Our ref: HA/2020/122604/01-L01
Your ref: LU/247/20/PL
Date: 15 October 2020

PARTIAL DEMOLITION OF EXISTING BUILDING, RETENTION OF BOUNDARY WALL & STREET FACADE, PARTIAL DEMOLITION OF BOUNDARY WALL TO INCORPORATE NEW PEDESTRIAN GATEWAY & GATE, ERECTION OF 6 NO. FLATS IN 2 BLOCKS CONNECTED BY SHARED STAIR & LIFT CORE, ON SITE PARKING YARD FOR 8 NO. CARS & 8 NO. CYCLES & SPACE FOR COMMUNAL REFUSE & RECYCLING BINS. THIS APPLICATION AFFECTS THE CHARACTER & APPEARANCE OF THE LITTLEHAMPTON RIVER ROAD CONSERVATION AREA & IS IN CIL ZONE 4 AND IS CIL LIABLE

57 RIVER ROAD LITTLEHAMPTON BN17 5DD

In the absence of an acceptable Flood Risk Assessment (FRA) we **object** to this application and recommend that planning permission is refused.

TITLE: PROPOSED SECTION A

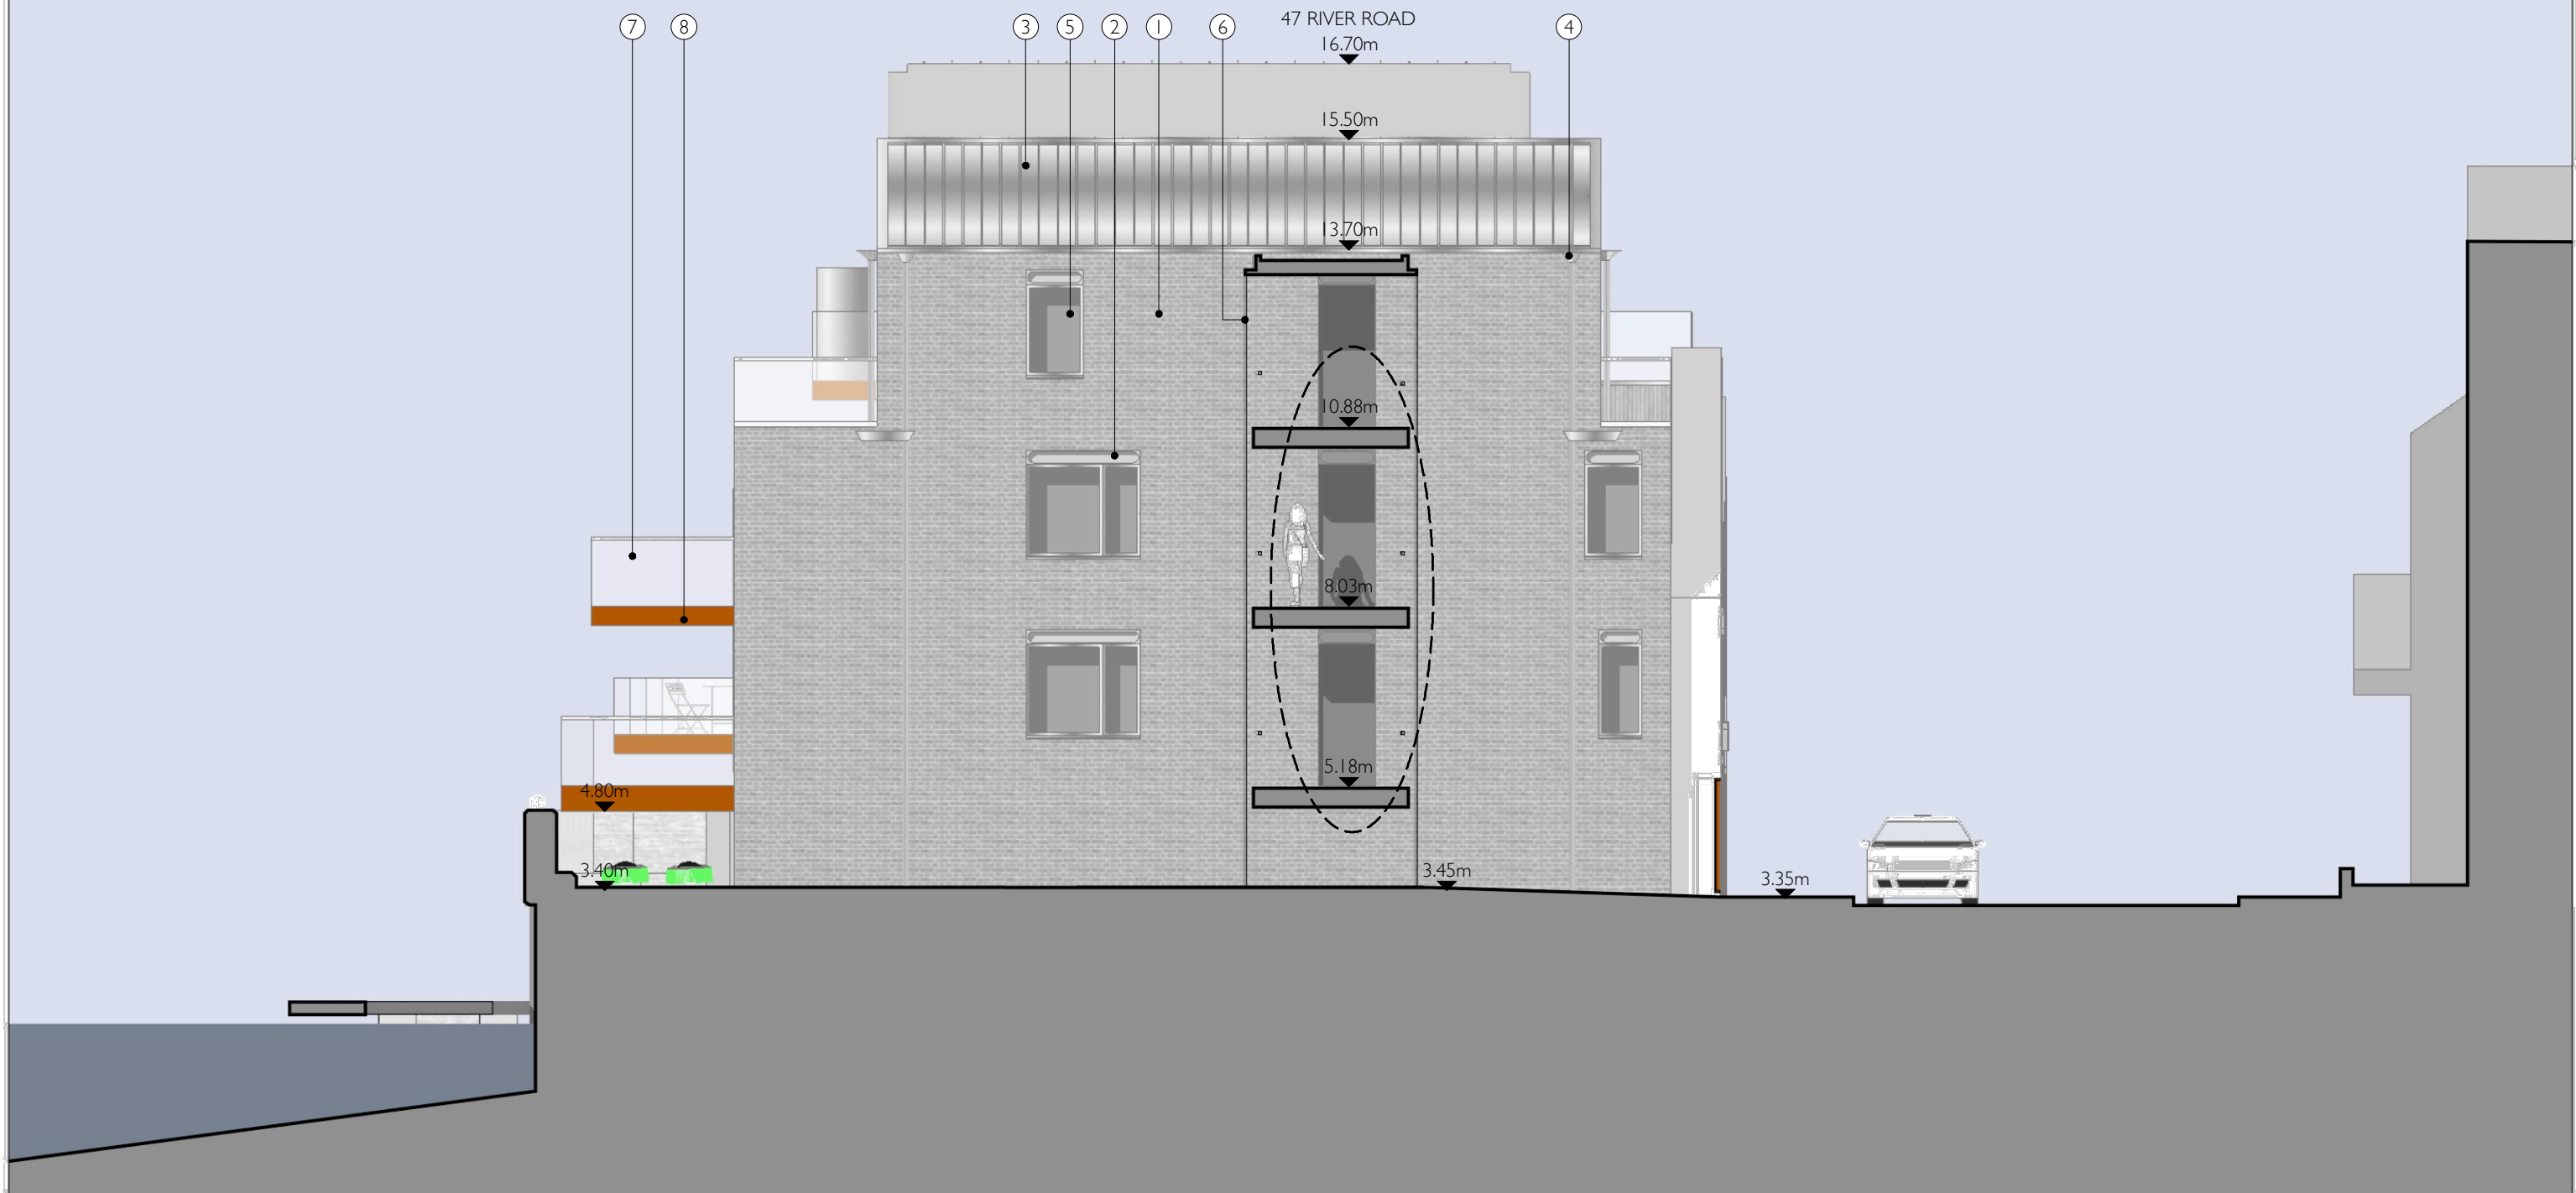
- provide site specific tidal flood levels in mAOD
- take the impacts of climate change into account
- Assess finished floor levels for the dwelling against the site specific tidal flood levels (including climate change) and include sufficient freeboard.
- consider how people will be kept safe from the identified flood hazards
- consider how a range of flooding events (including extreme events) will affect people and property
- consider the requirement for flood emergency planning including flood warning and

The data used in the FRA is out of date (2013 and older). Please provide an FRA using the most up-to-date data available.
